Wilby Manor Barns, Wooten Green, Wilby, Suffolk, IP21 5LB

Wilby Manor Barns have been granted planning and listed consent for conversion. Full planning and listed consent was granted under DC/21/04312 Planning and DC/21/04313 Listed Consent. The barns were in a state of partial collapse and at planning stage a structural engineer had confirmed safe access was not possible hence the conditions applied to the consents.

## Matters Arising from Heritage Visit During Construction

| WD04 | 547 | CONSTRUCTION | D |

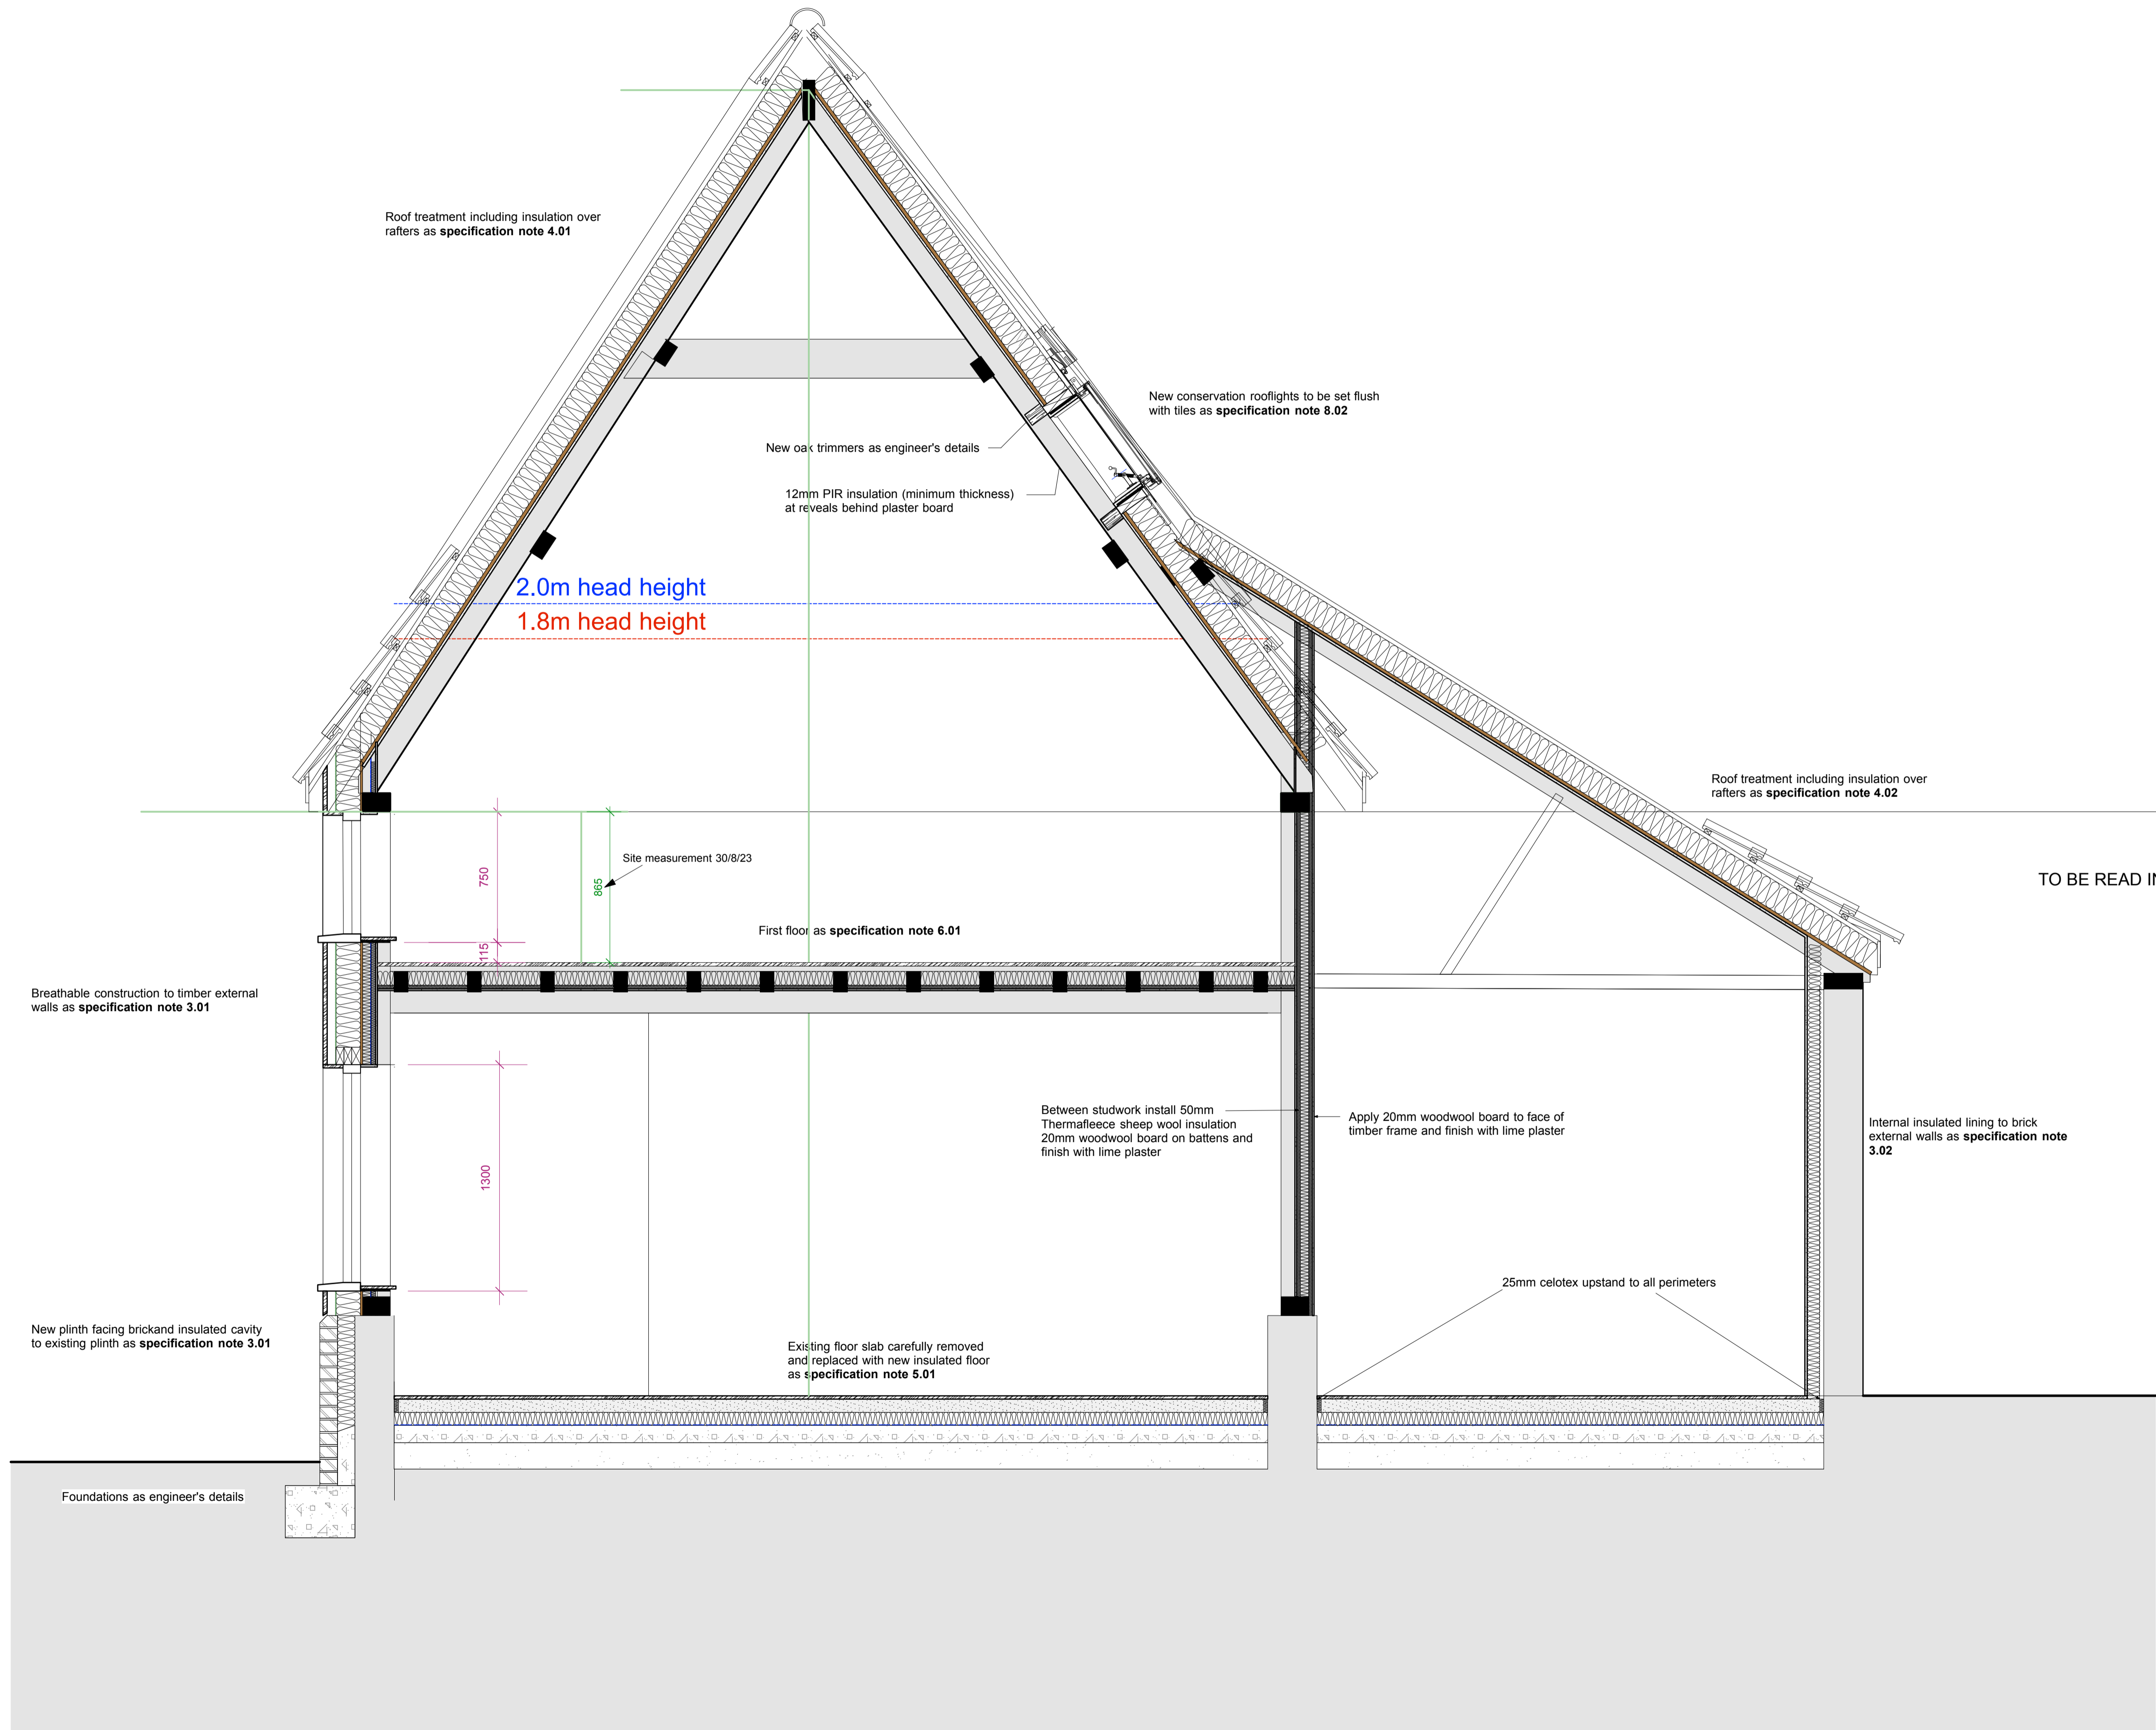
Condition 4 (Details of New Wall and Roof Build-Up) – This condition was applied as ‘notwithstanding,’ which is designed to mean that there is not yet any approval for any works listed in the condition, even if such works are shown on documents listed in the decision notice. Having reviewed my photographs from the site visit, it also appears that the roof insulation in the single storey range does not match the section drawing included in the original application anyway, as the Celotex? insulation has been installed between the rafters in this range. Again, I would therefore request that to start with a Discharge of Conditions Application to either retain or amend these works, with clear and convincing justification and measured section drawings, as per the condition wording, is submitted ASAP.

See attached drawing WD04D. The principle of insulating externally as shown on the approved section drawing submitted with planning application and listed conditions and approved with both. This exact build up has been approved on numerous barns in Mid Suffolk including many that are curtilage listed or indeed in some cases they are listed individually.

By utilising Celotex externally as a sheathing it ensures there is no risk of interstitial condensation and the full depth of frame remains on show as it would have been in the original building.

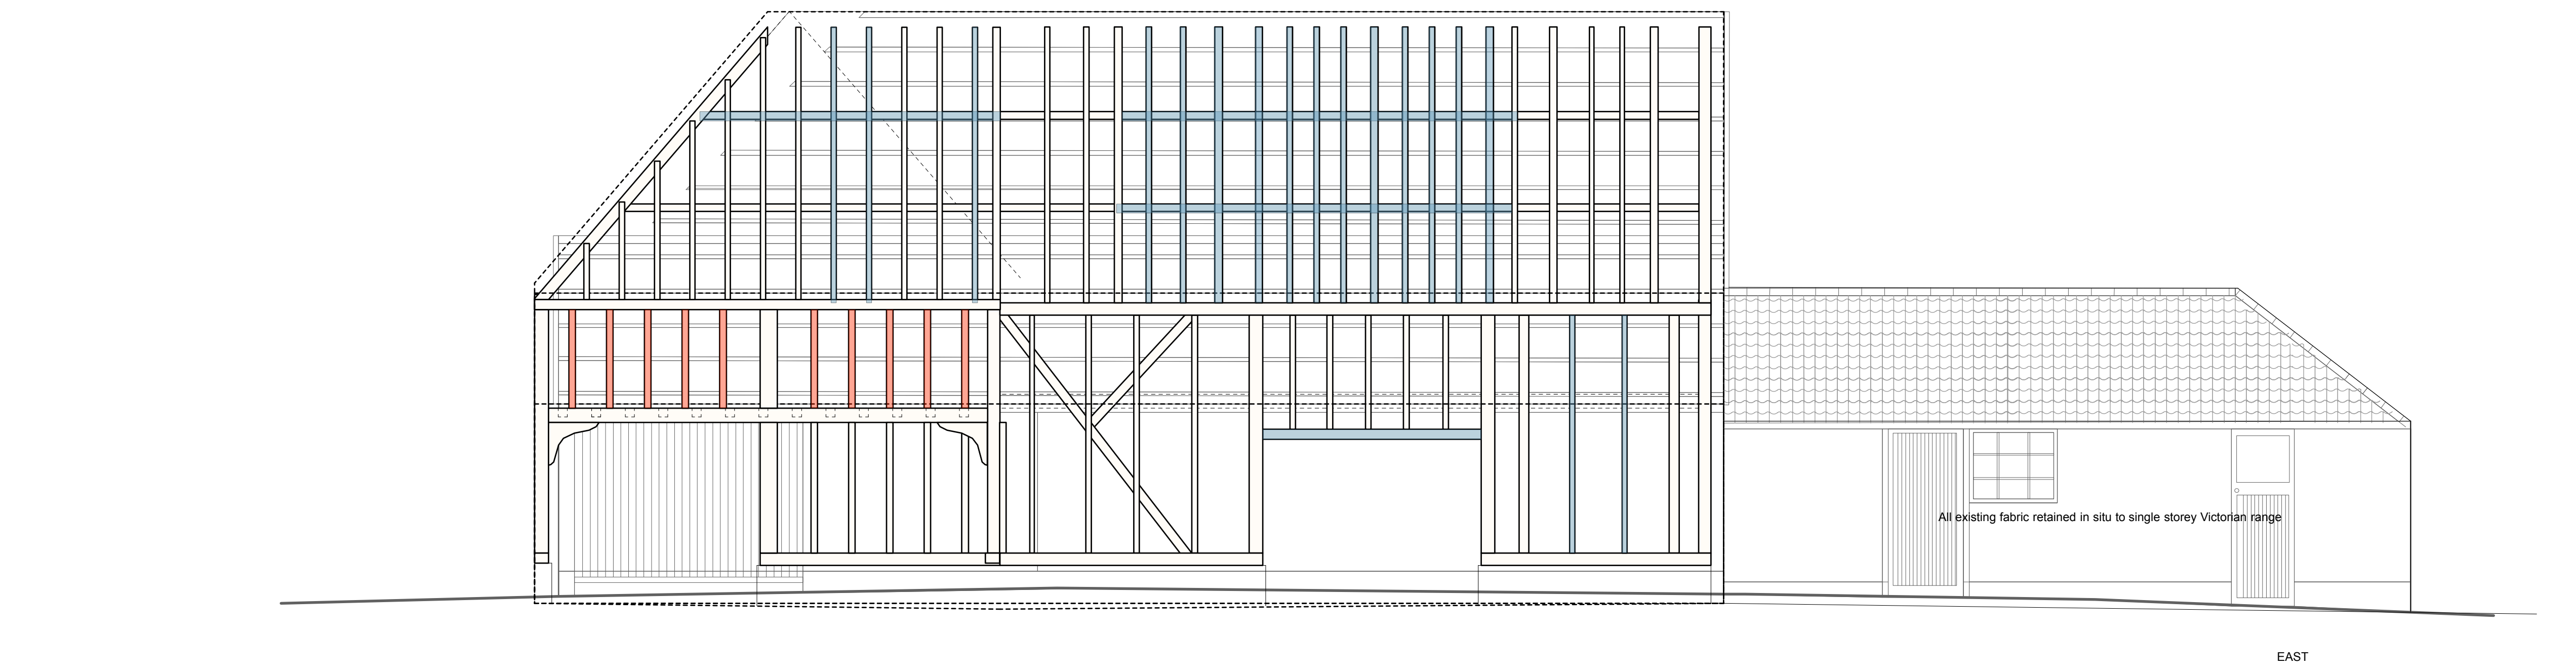
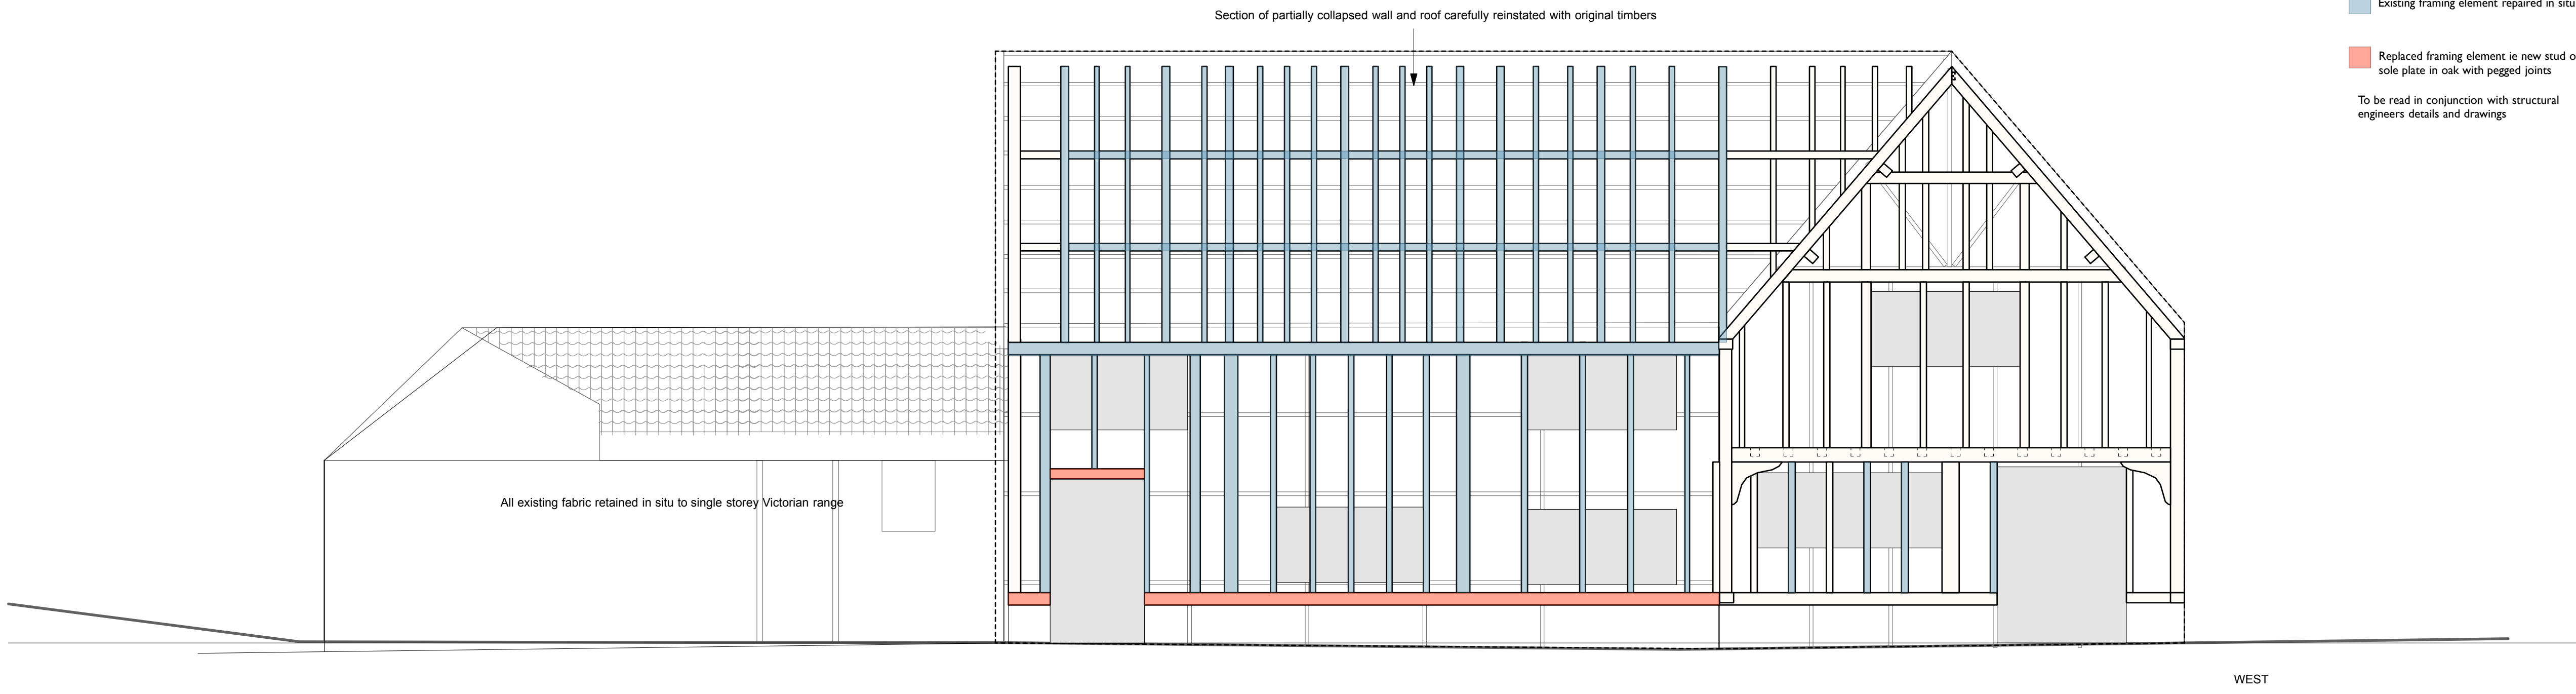
Condition 3 – Details of Timber and Brickwork Details – It was evident from the site visit that more timber frame repairs/replacement have been conducted than detailed under the current Discharge of Condition DC/24/00317. The condition wording requires agreement to “any repair of underlying timber frame and brickwork.” The drawing seen on site that seems to be being used in regard to the timber repairs, numbered R/21/052, does not seem to have formed part of the approval. The R/21/052 listed in the decision notice seems to be the attached document, which is not a drawing, nor a document I would consider a suitable schedule of frame repairs, hence the application of the condition. To start with, I would therefore request that you submit a further Discharge of Conditions application for this condition, or add to DC/24/00317, to retain these works, ASAP, detailing the other repairs/replacement conducted – for the extent of works seen on site, I consider that this would require measured frame drawings for the walls and roofs, making clear the extent of replacement, and any evidence you have at this stage to justify the need for the repairs conducted so far.

3) Floor Joists -The entirety of first floor joists across the barn have been replaced. I consider that these were of some historic interest. Again, limited evidence to justify wholesale replacement has been provided. Having viewed the limited extent of previous joists that had been retained on site, it was not immediately apparent that they were beyond retention, but they have been deliberately cut in order to remove them, and as such reinstatement of any of the previous joists now seems impractical. As above, I would however request detail of the methods used to install/fix the new joists to existing fabric.

We have attached drawings WD12, WD13 and WD14 showing all timber repairs and replacements across the scheme.
